PLAN REVIEW SHEET

Date: December 15, 2020

Petition #: RZP 2020-197

Request: UR-2 (CD)

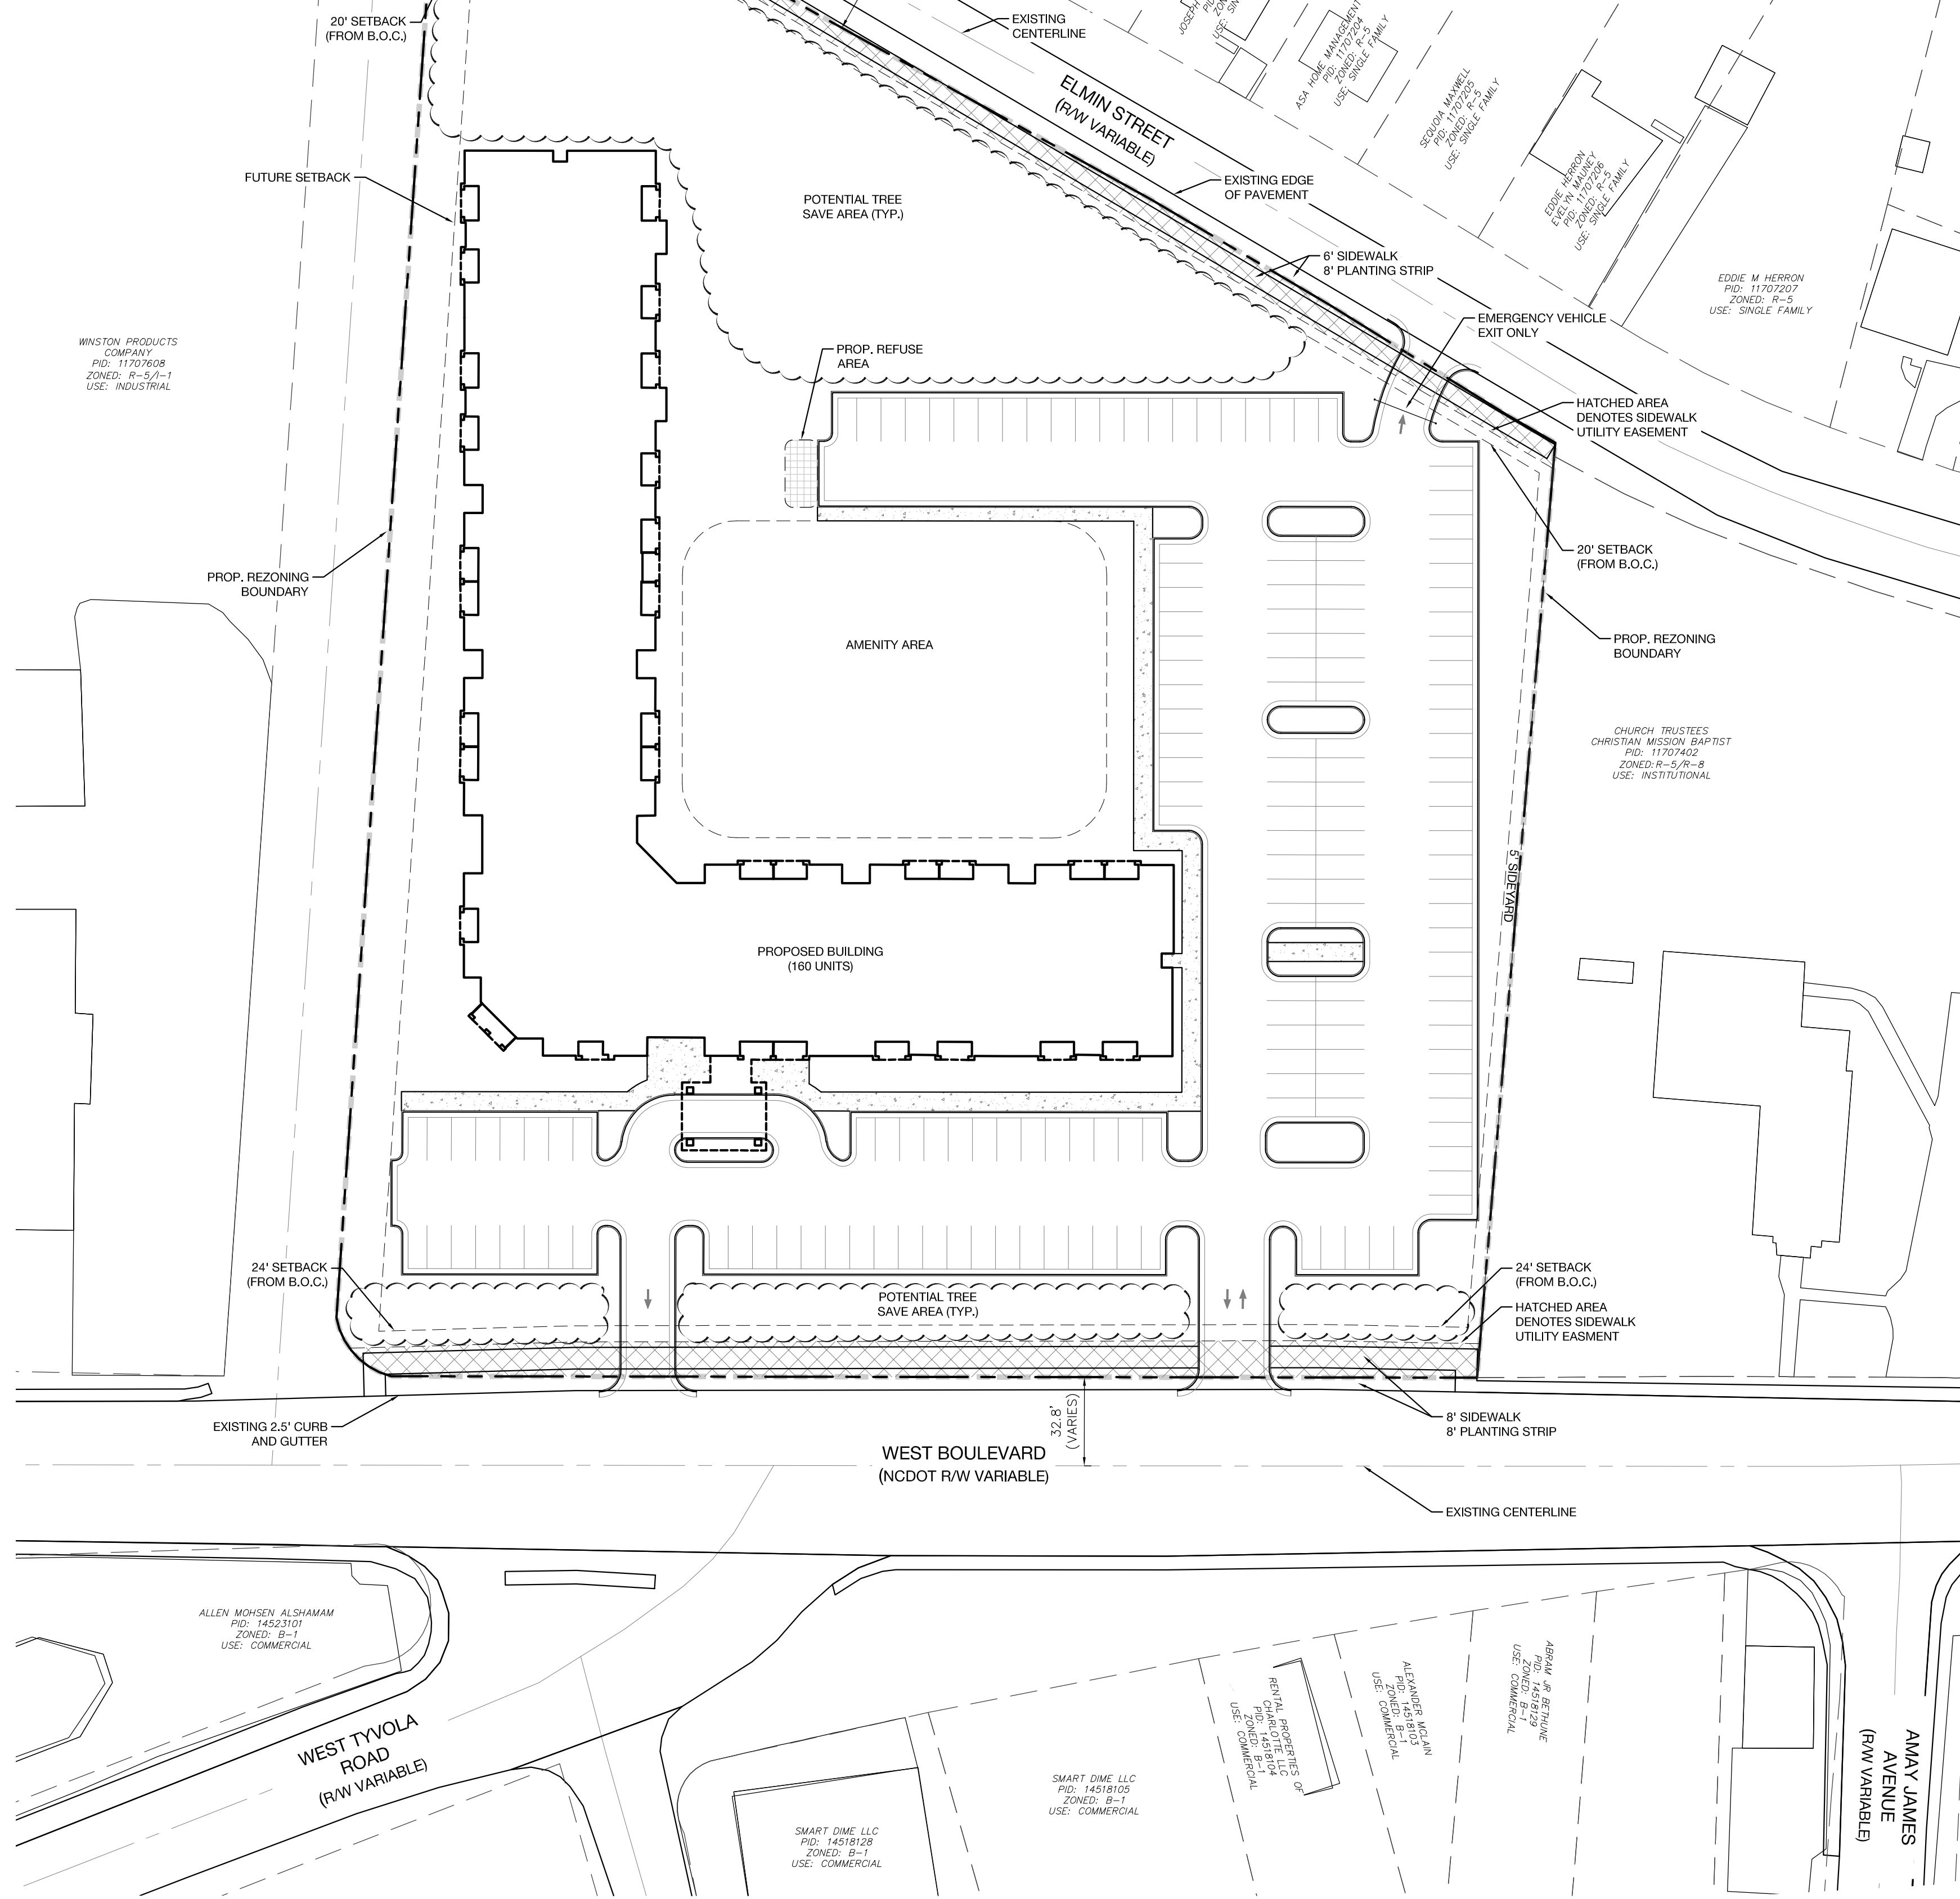
The site is located along CATS local bus route #10 on West Boulevard. CATS requests the petitioner to construct a new ADA compliant bus waiting pad per Land Development Standard 60.01B along West Boulevard for outbound stop #34580. The final location of the pad will be coordinated with the developer through the permitting process.
